Dartbrook Mine DA 231-7-2000 MOD 7 Submission

I refer to the application by AQC Dartbrook Management P/L (the Proponent) for modification to the proposed extraction method for coal mining at Dartbrook Mine (DA 231-7-2000 MOD 7) that is being exhibited from 28 June 2018 to 25 July 2018. On the basis of information supplied in the Environmental Assessment (EA) dated 15 June 2018, and meetings with the proponent on 18 July 2018, I make the following submission on behalf of Muswellbrook Shire Council. Council appreciates the opportunity for comment on the modification.

Conceptual Modification Layout

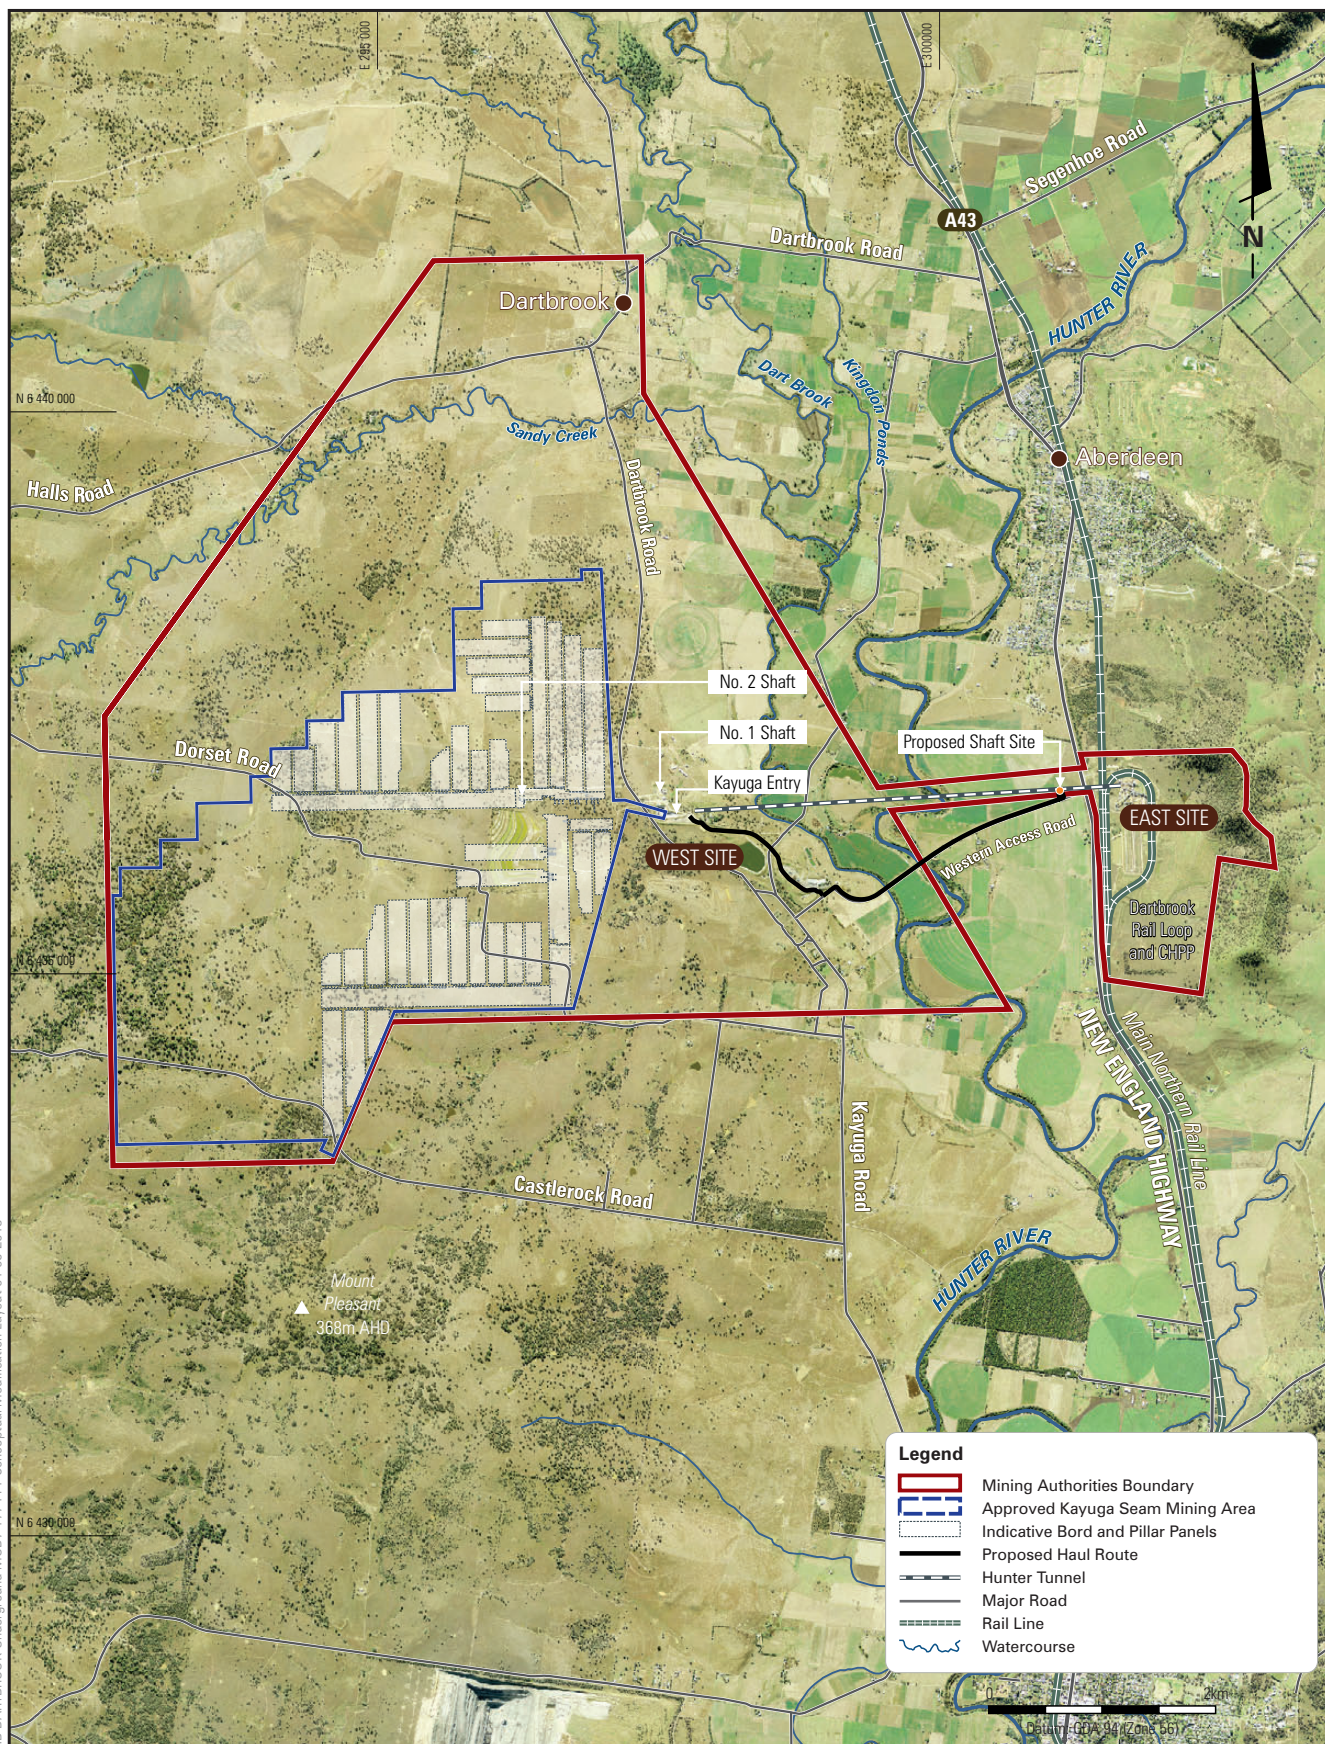
4.4 The shed over the proposed shaft into the Hunter Tunnel is of a drive through design and not the conventional 3 sided design with rubber belting and water sprays. This will make it far more difficult to contain coal dust when the coal is being dumped from the B-double trucks into the proposed shaft. This dust will be clearly visible from the New England Highway. The proposed shed needs to be designed to contain the dust as far as possible, and external screen walls/mounds placed on the site to obscure dust spill from the shed from the New England Highway.

6.2 It is noted that the EA advised that it is not known if the proposed shaft into the Hunter Tunnel is within the Hunter River alluvium and so will bear water. A test bore of the site should be undertaken to determine this prior to any construction. Revised consent conditions need to require the shaft to be lined if the test bore proves alluvium water will be encountered, to ensure no unnecessary alluvial water is lost to the Hunter Tunnel at any time.
